**TOWER 2, LEVEL 23  
DARLING PARK, 201 SUSSEX ST  
SYDNEY NSW 2000**

## **SSD 16\_7683: NEW RESTAURANT AND MICRO-BREWERY, OVERSEAS PASSENGER TERMINAL (TENANCY 5)**

**HERITAGE OBJECTION: SSD 16\_7683  
PROPOSED BREWERY AND OUTDOOR BAR  
TENANCY 5, OVERSEAS PASSENGER  
TERMINAL, CIRCULAR QUAY**

Level 1 Proposed
1:200 @ A3
July 2016
SK
257_ADA_012 F

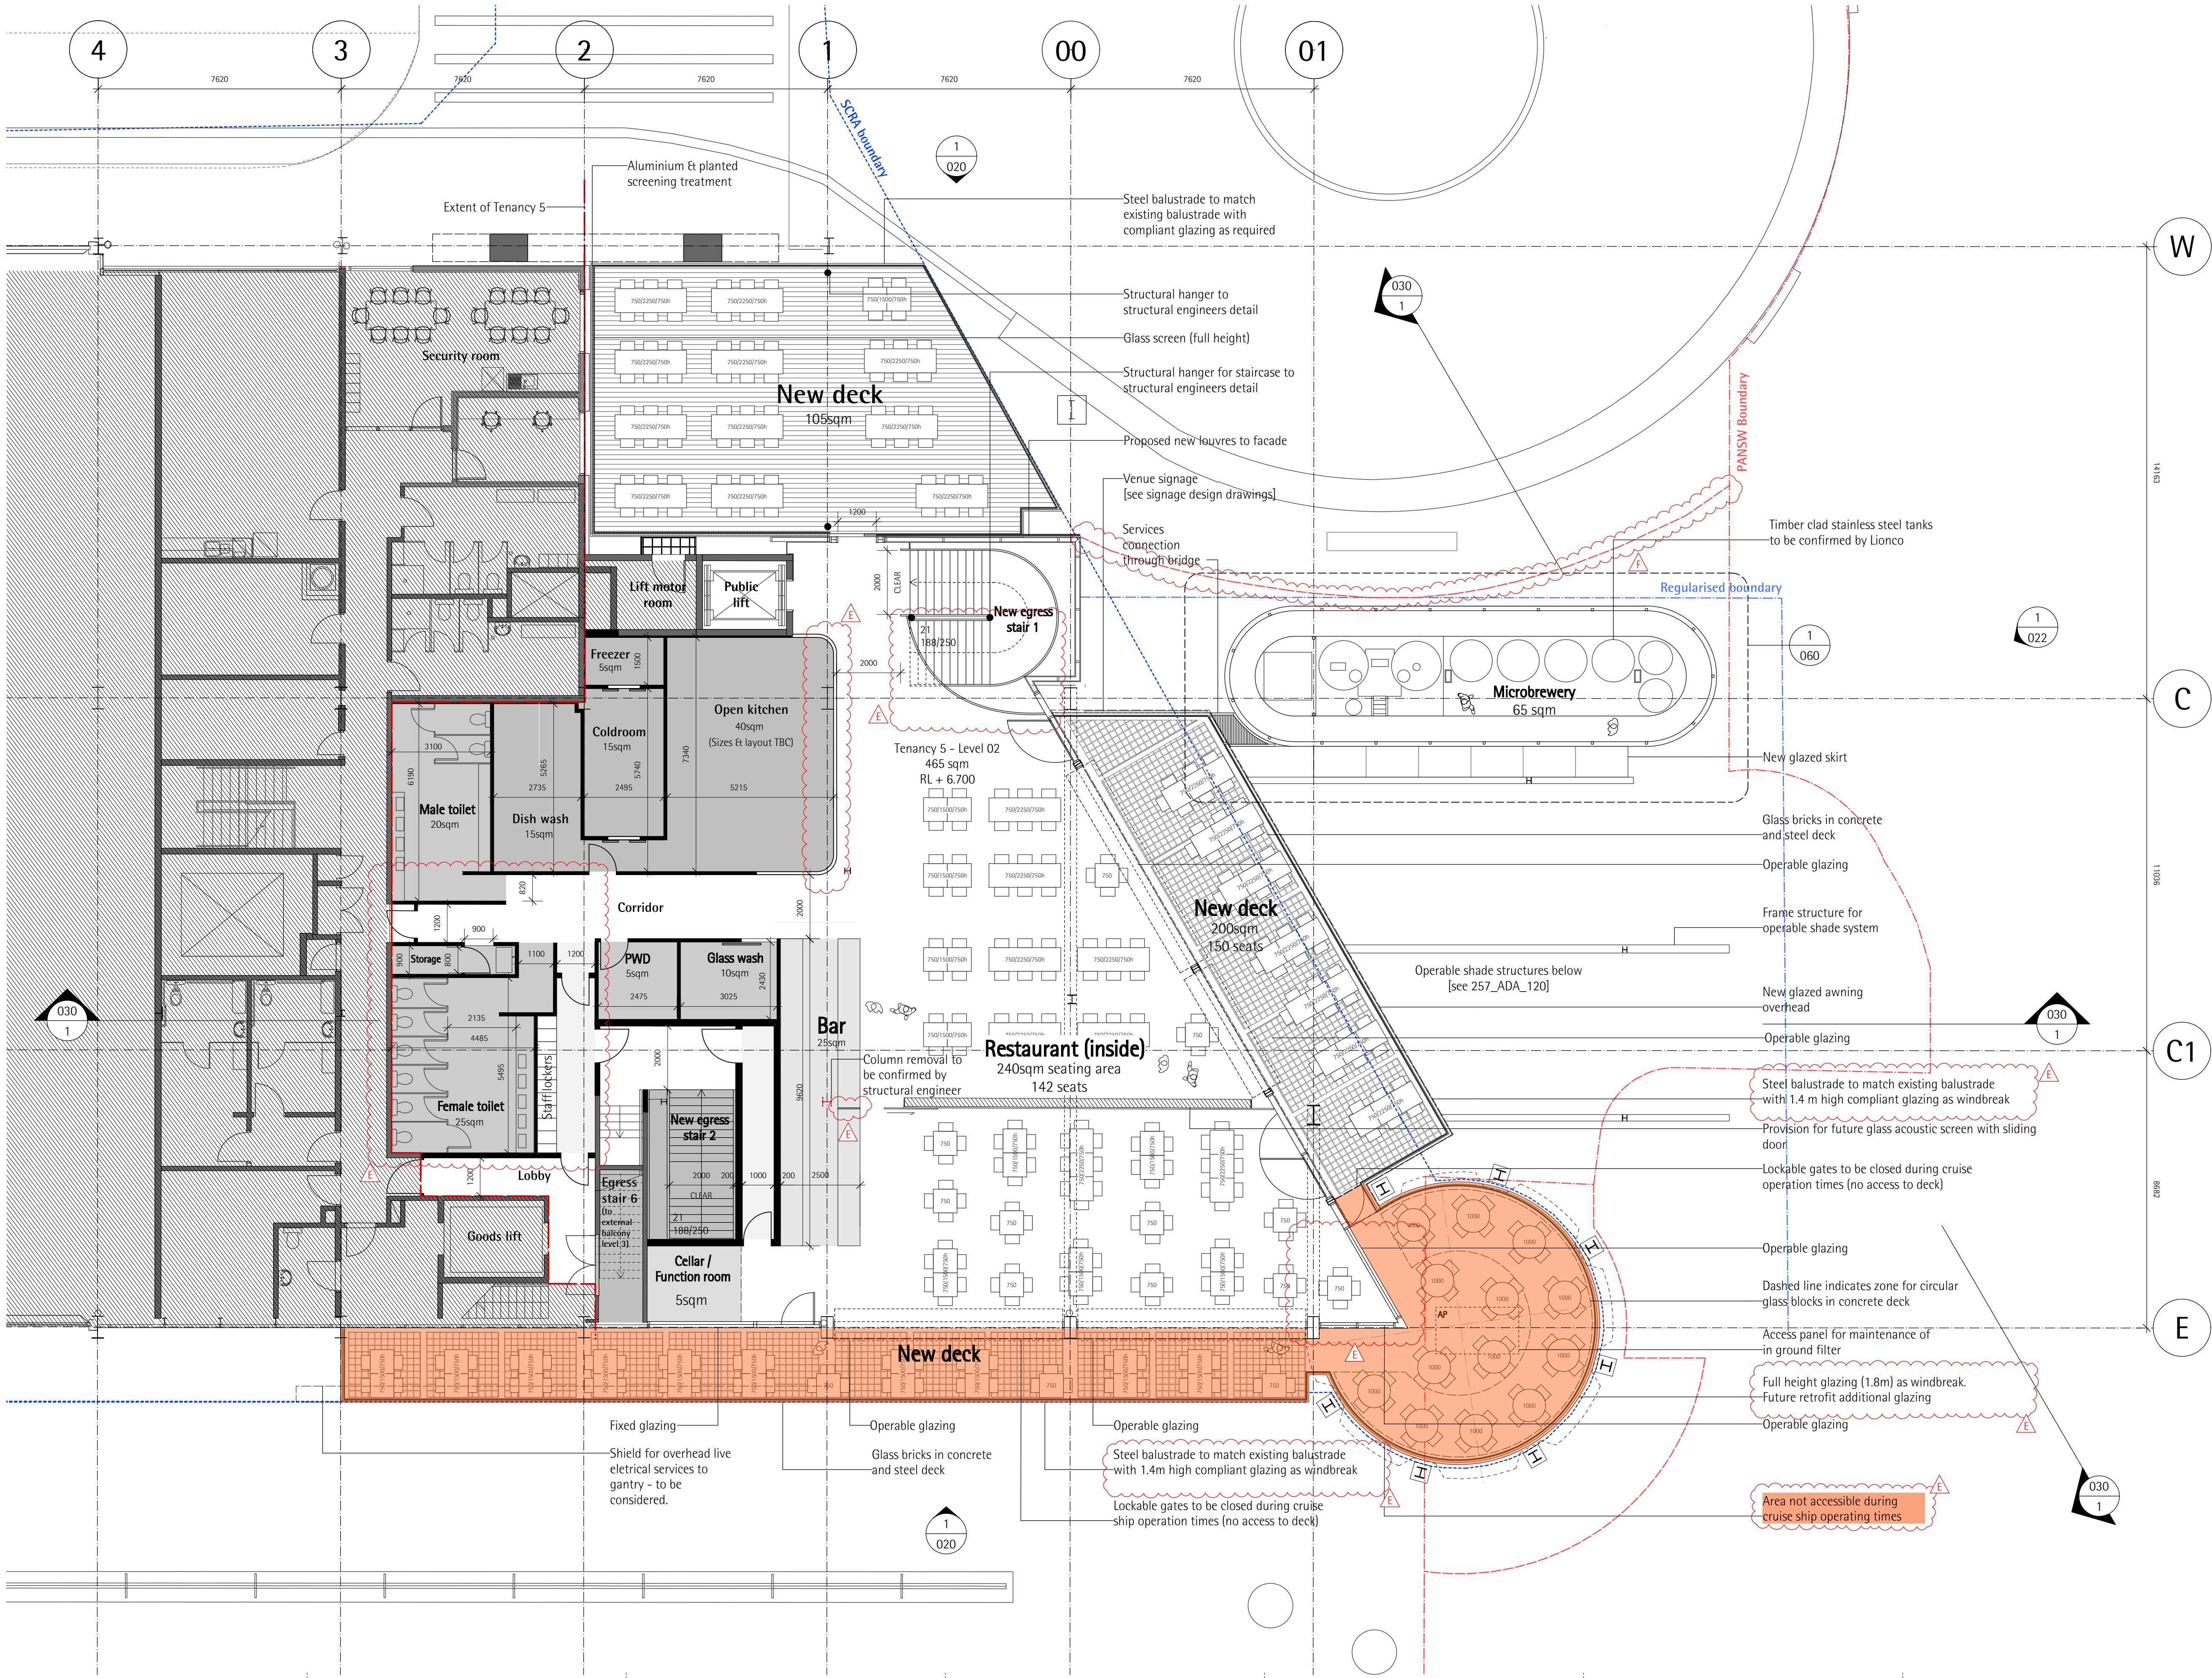
The proposed external micro-brewery pod and the first-floor deck is located outside of the existing OPT building envelope and site boundary identified in the Sydney Cove Redevelopment Authority Scheme (SCRA). The proposal therefore requires a significant variation to the SCRA Scheme. The justification provided for such a significant variation to the SCRA Scheme is inadequate.

1. Elevated oval shaped glazed "pod" containing a series of tanks forming the micro-brewery.
2. External signage
3. A series of external decks on the northern, eastern and western facades, including a glazed awning above the new northern deck.
